KIRKLEES METROPOLITAN COUNCIL INVESTMENT & REGENERATION SERVICE

DELEGATED DECISION TO DETERMINE PLANNING APPLICATIONS

Reference No:	2022/62/90514/W
Site Address:	75, Imperial Road, Edgerton, Huddersfield, HD1 4PG
Description:	Erection of single storey rear extension and external alterations
Recommending Officer:	Lucy Taylor

Officer Report.

Drawing Title
Proposed Block Plan

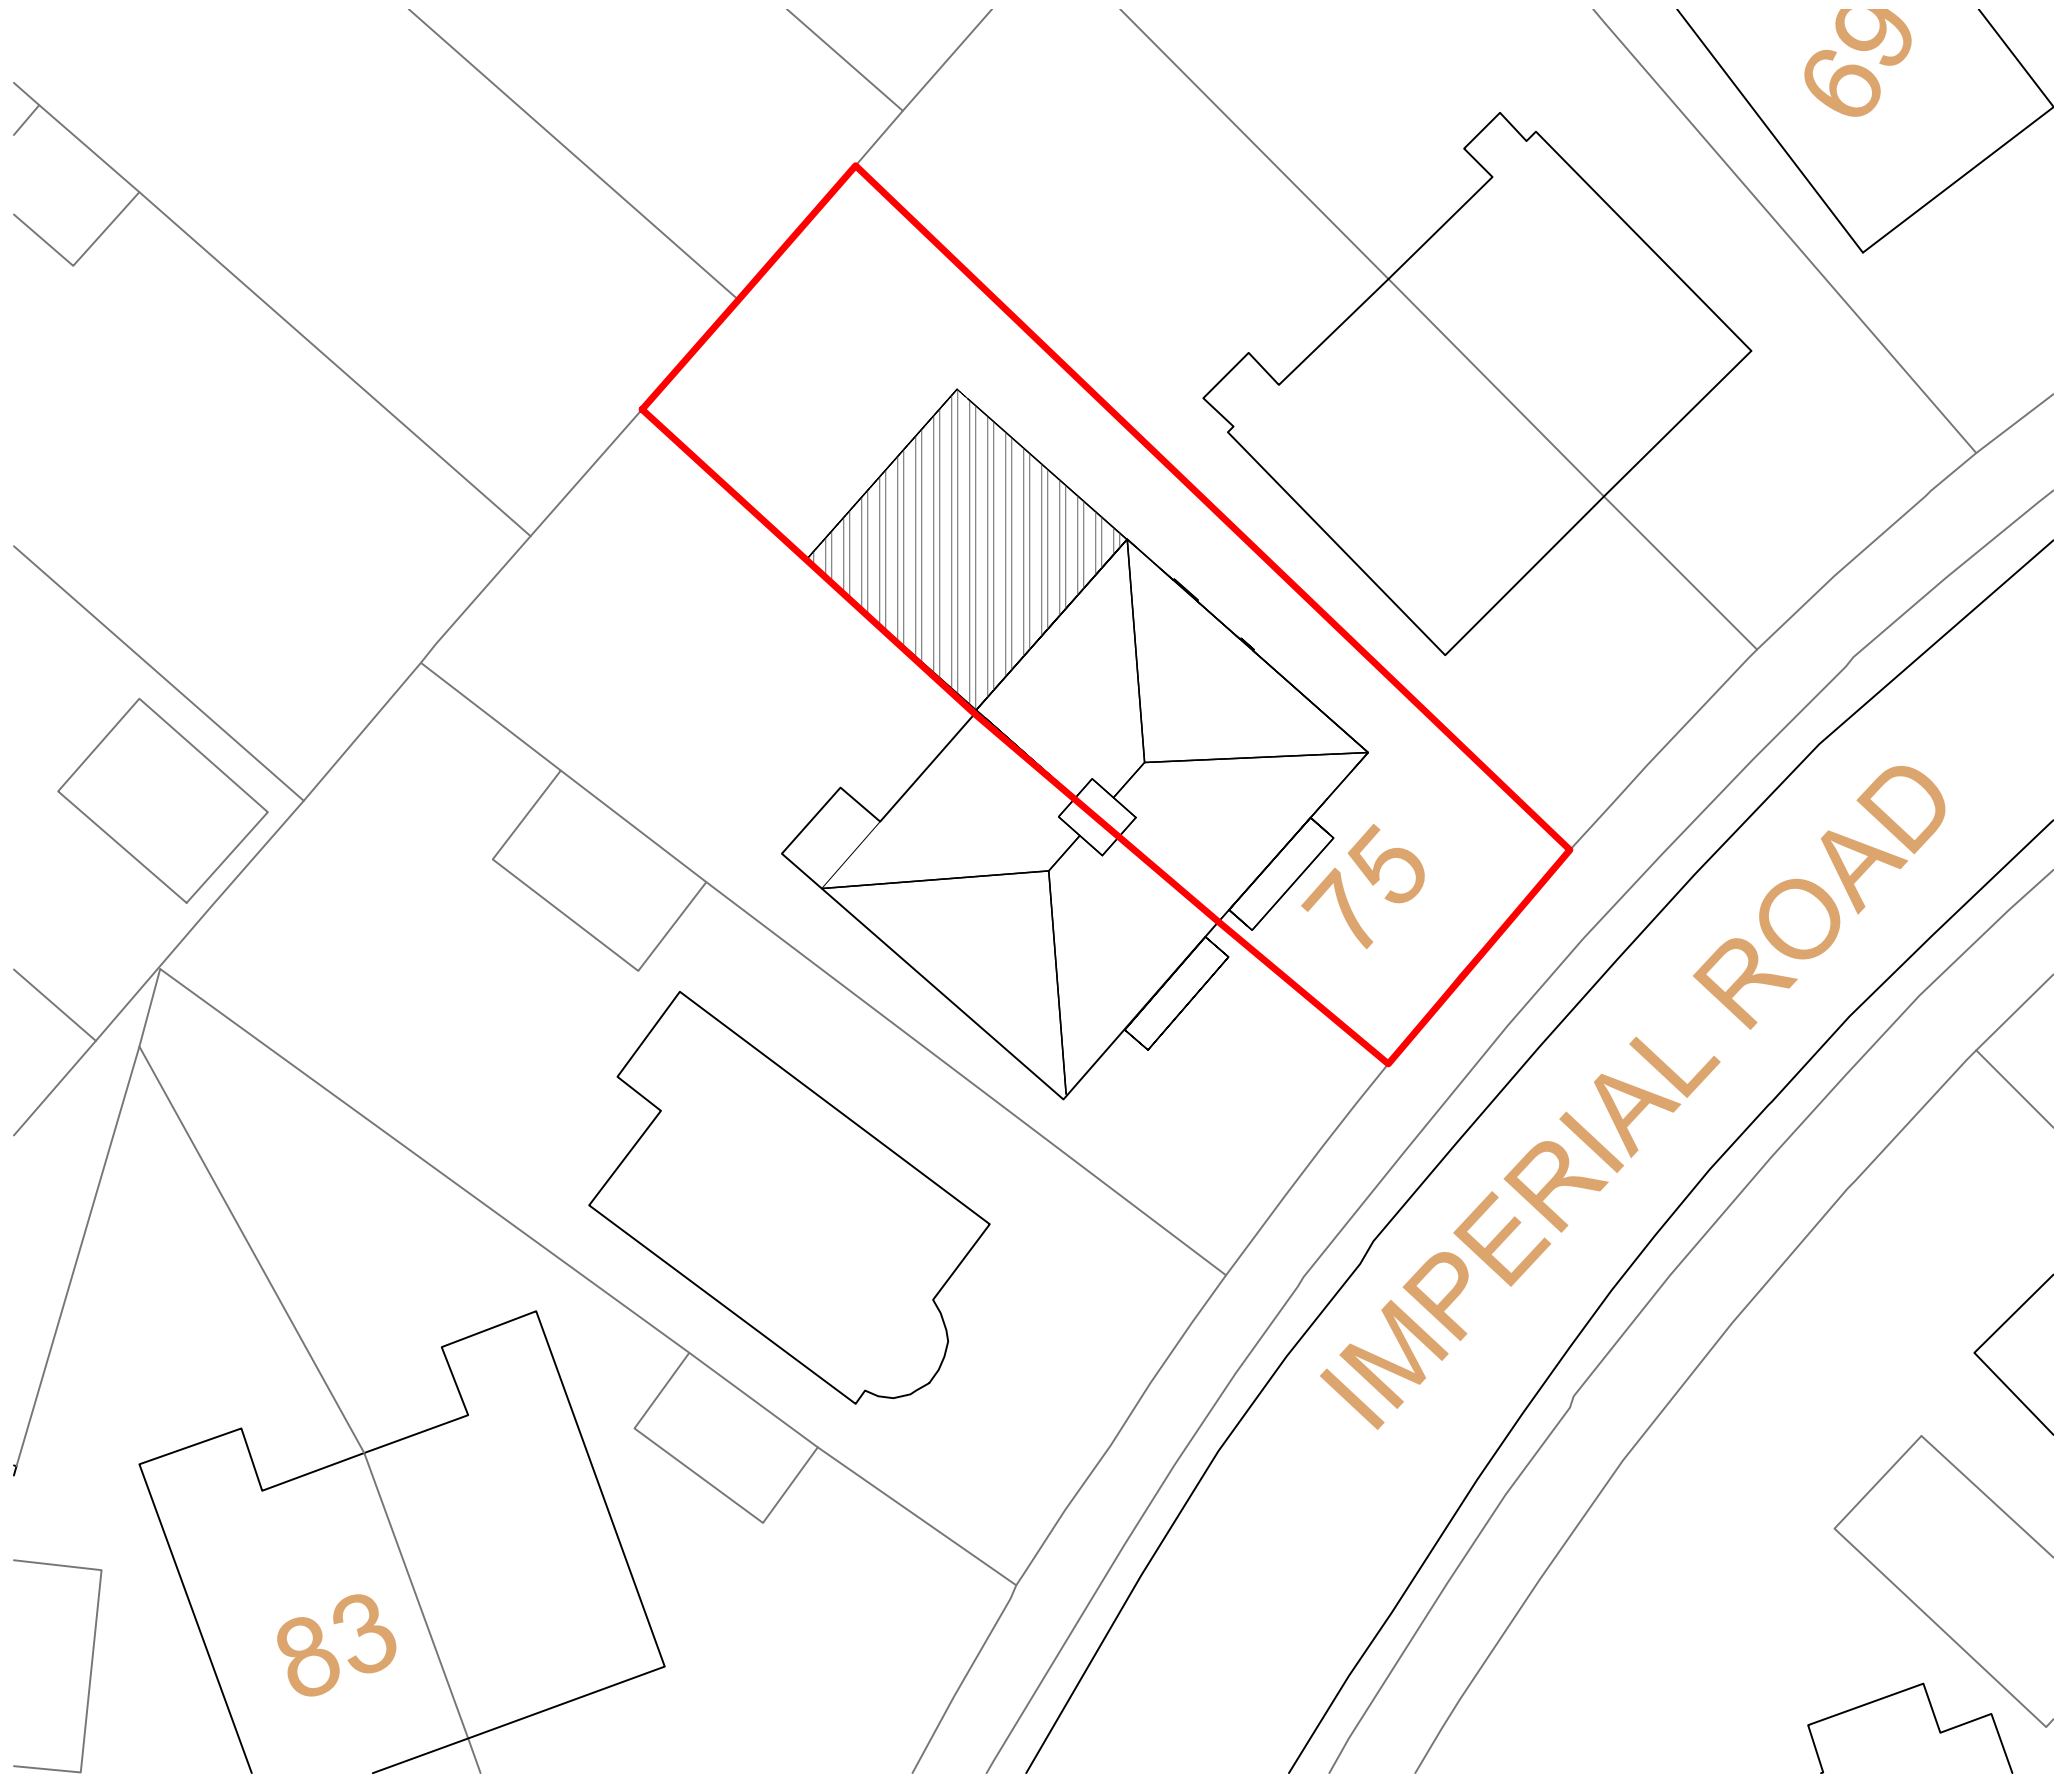
Key Design Principle 7 of the SPD requires a functional garden space to be retained as part of any development. The proposed rear extension to 75 Imperial Road would reduce the existing size of the rear garden by half. However, some rear garden amenity space would be retained and therefore, the development accords with the aims of Key Design Principle 7.

The proposed rear extension to 75 Imperial Road would be located a significant distance from the shared rear boundaries of curtilage (approx. 6 metres) with No's 43 and 45, and would be an even further distance from the location of the main properties themselves (approx. 27 metres).

Side Elevation Proposed -
view from adjacent property

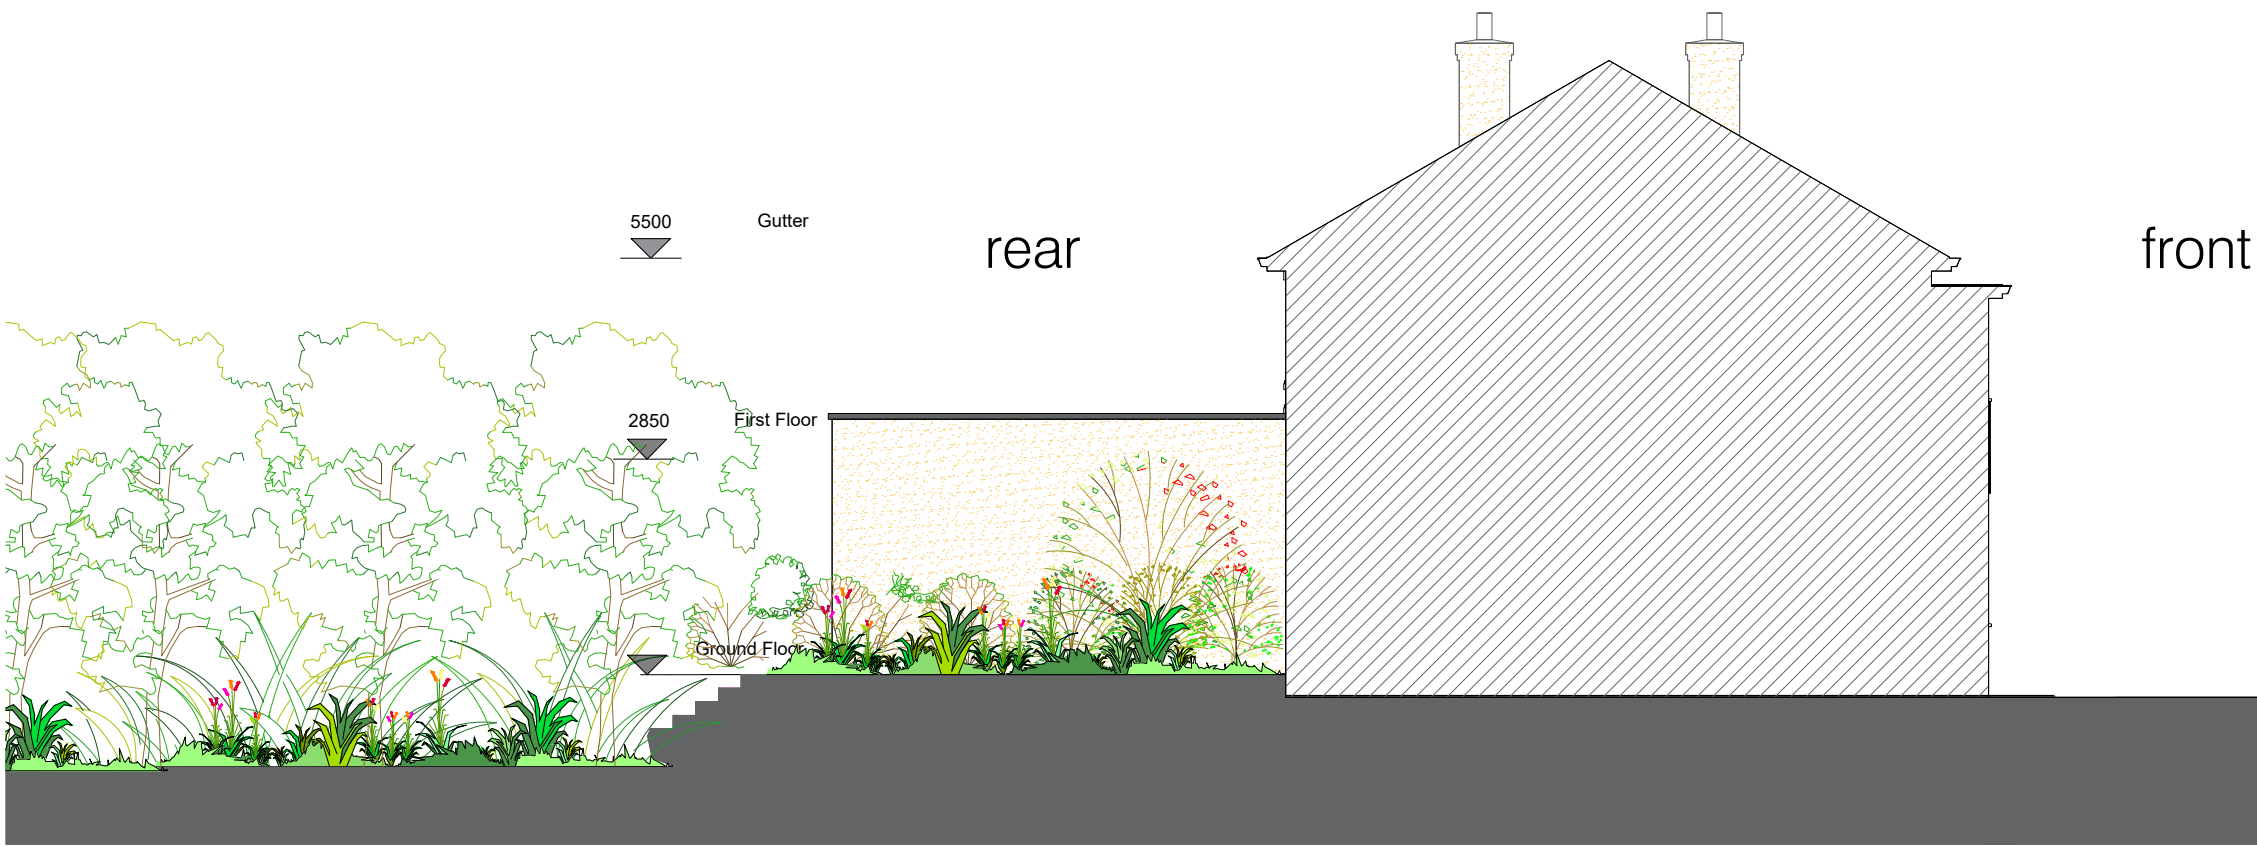
Given the size/scale of the proposed rear extension to 75 Imperial Road, and the siting of the solid western side elevation along the shared boundary, its erection would result in undue impacts of overbearing and overshadowing for the occupiers of this neighbouring property.

- The side wall to the boundary with the neighbouring property has no features or interest in it and just appears from the plans to be a large expanse of red brick. This will be dark and uninteresting and increase the wind tunnel effect between the two houses.
